CONSULTEE RESPONSE (Arun District Council - Arboriculturist)

Reference: AB/17/26/HH

Proposal: Construction of single storey side extension with steps to rear and conversion of garage to habitable use.

Location: 37 Torton Hill Road, Arundel, BN18 9HF

Drawing Title: Arboricultural Impact Assessment

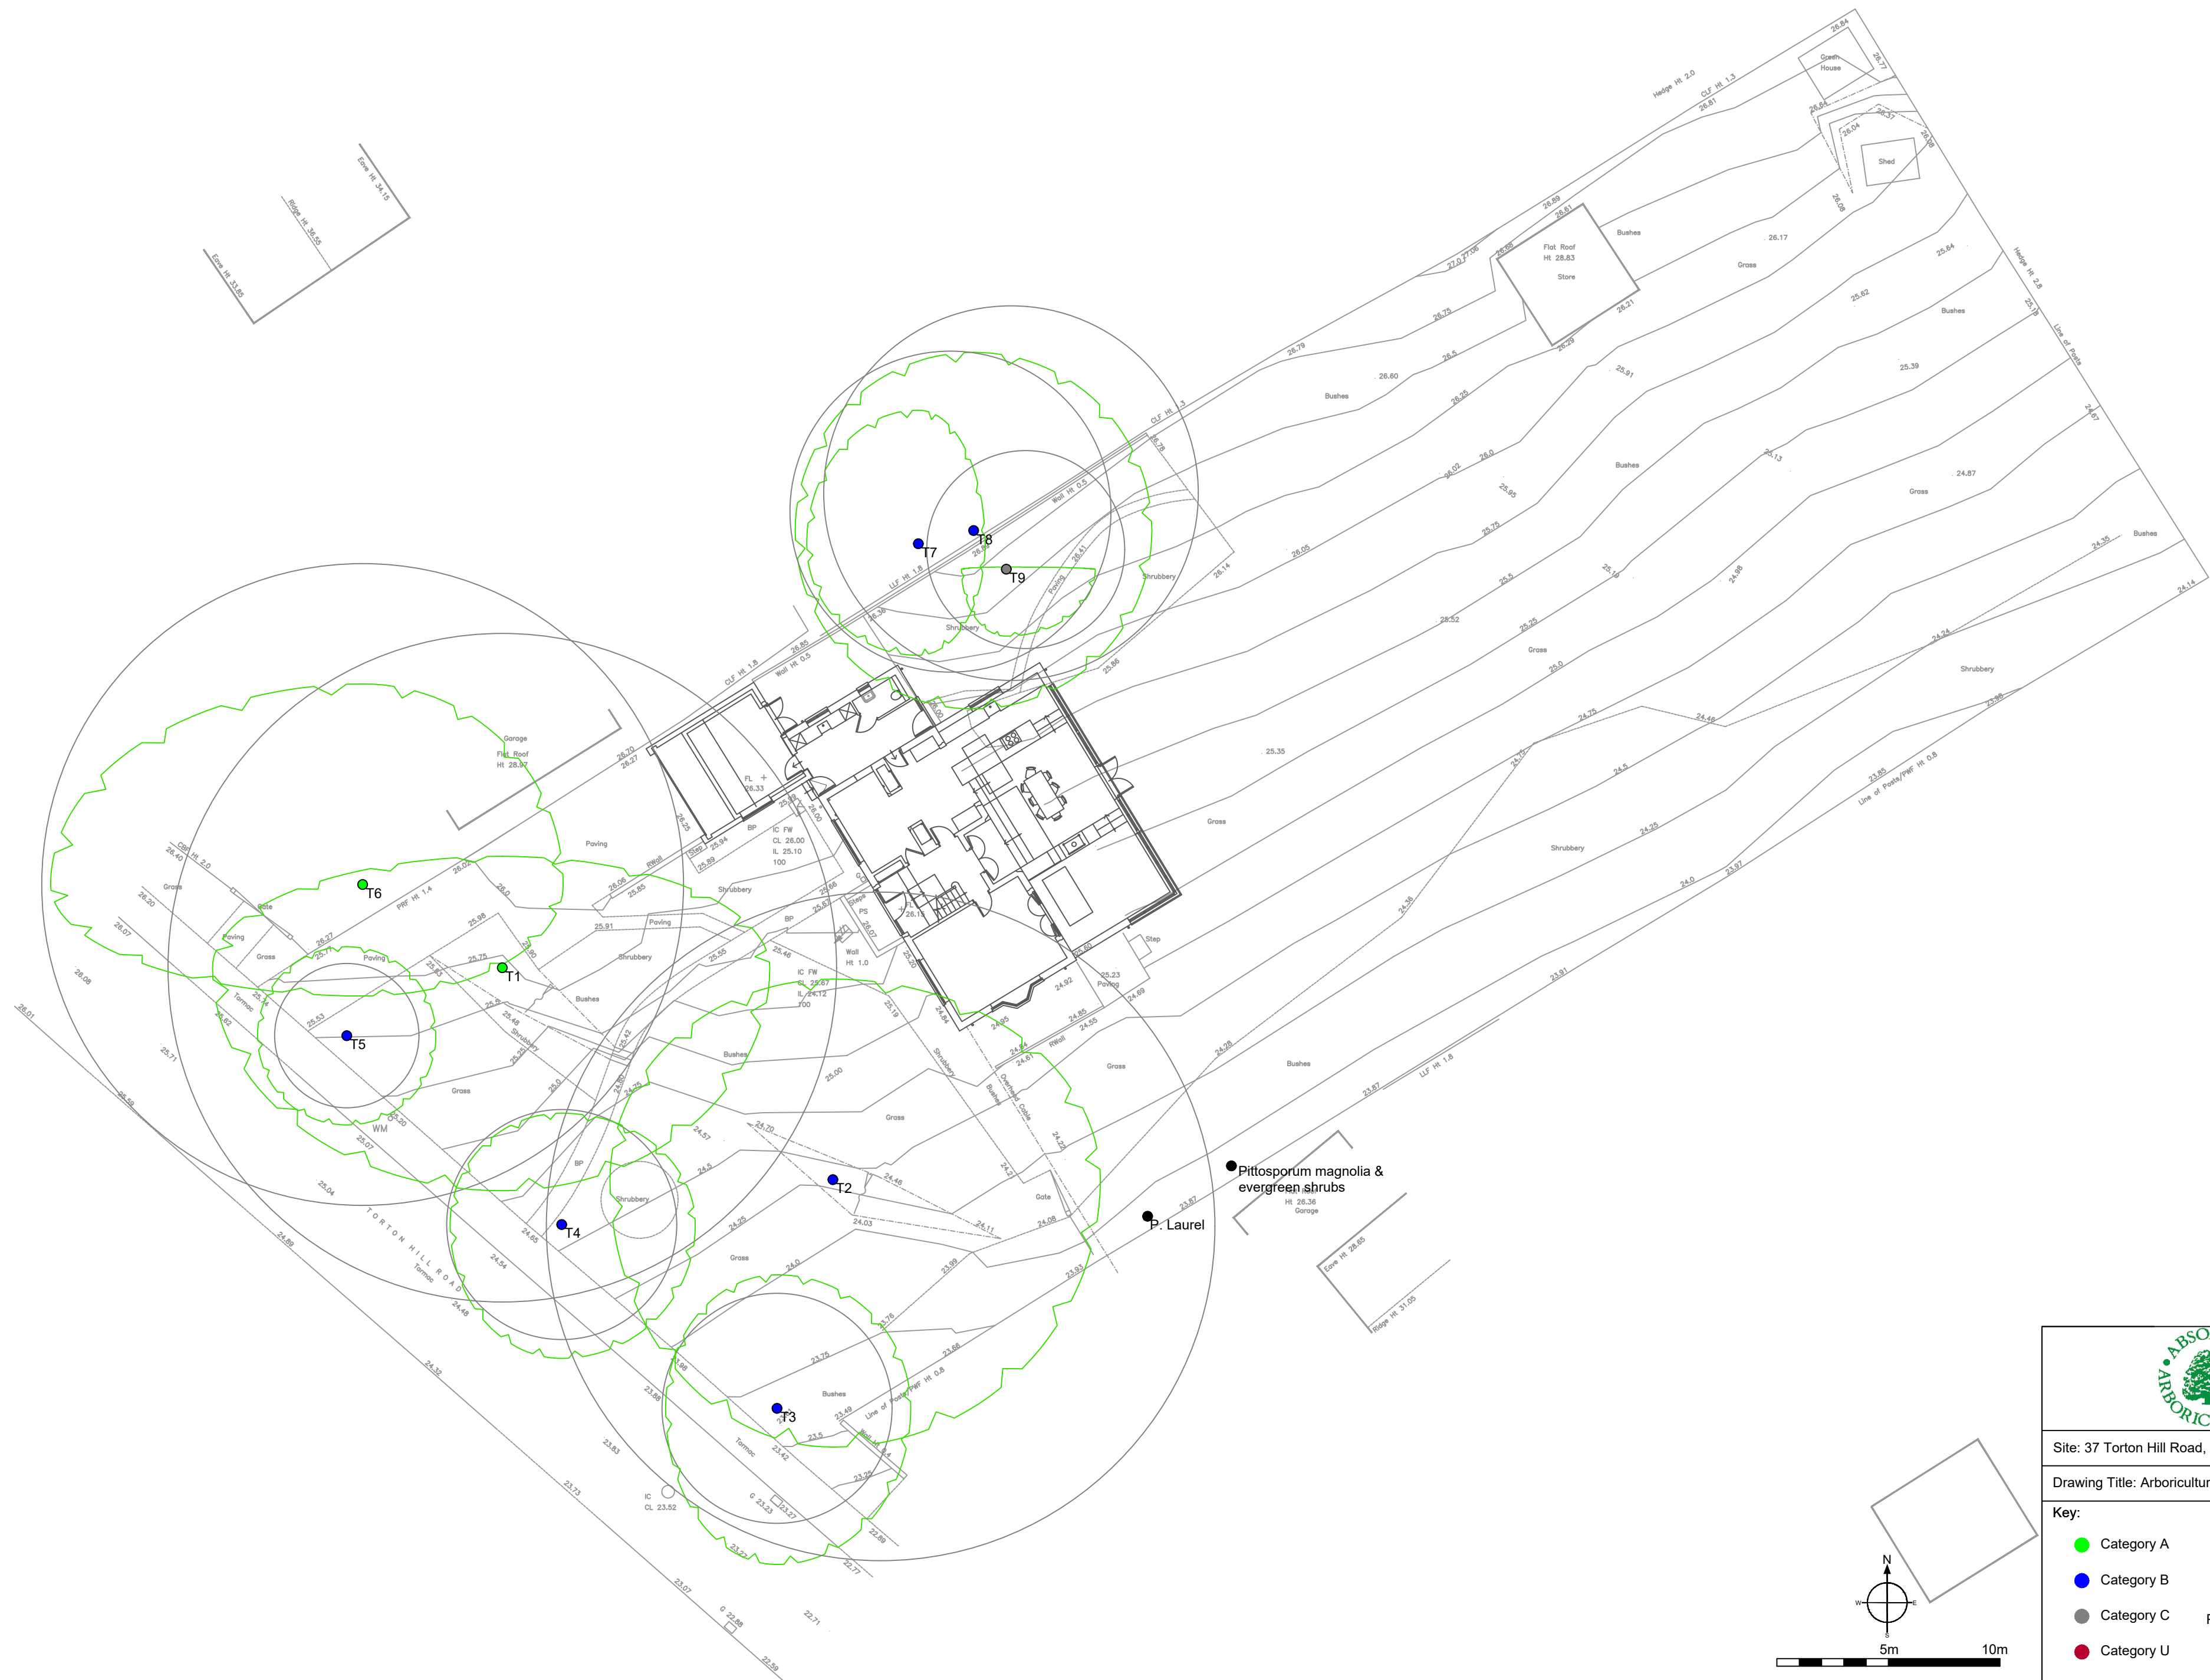
The site is remarkable for the presence of mature oak trees, prominent at the front of property. Several are justifiably rated as retention Category A and the majority of other trees rated B. A high frequency of movement to transport plant and materials to the rear of the dwelling is planned.

Whilst the maintenance of all physical tree protection measures (i.e. fencing and ground cover) is an essential requirement; the correct installation and ongoing implementation of effective ground protection to facilitate the proposed 'contractor access route' is a critical element for the successful delivery of this project. Its proximity to T1, T2 & T6 (all subjects of TPO) and sustained use, will require regular oversight to prevent damage occurring to the underlying soil structure. No storage of plant or materials upon the ground protection should be permitted, to reduce the risk of pollutants harming soil flora and fauna.

I would advise some type of fencing (e.g. plastic barrier mesh) is installed either side of the contractor access route, to further insure against any deviation onto unprotected ground within the RPA of important trees.

Before any machinery is introduced to the site or construction work takes place, a brief written report (with supporting photographic evidence) is required from the Arboricultural Consultant representing the site owner(s), confirming and demonstrating that all ground protection and protective fencing has been assessed and is 'Fit for Purpose' as required under British Standard 5837:2012 and been erected and positioned exactly as shown on the **Tree Protection Plan, Rev B April 2026, Absolute Arboriculture.**
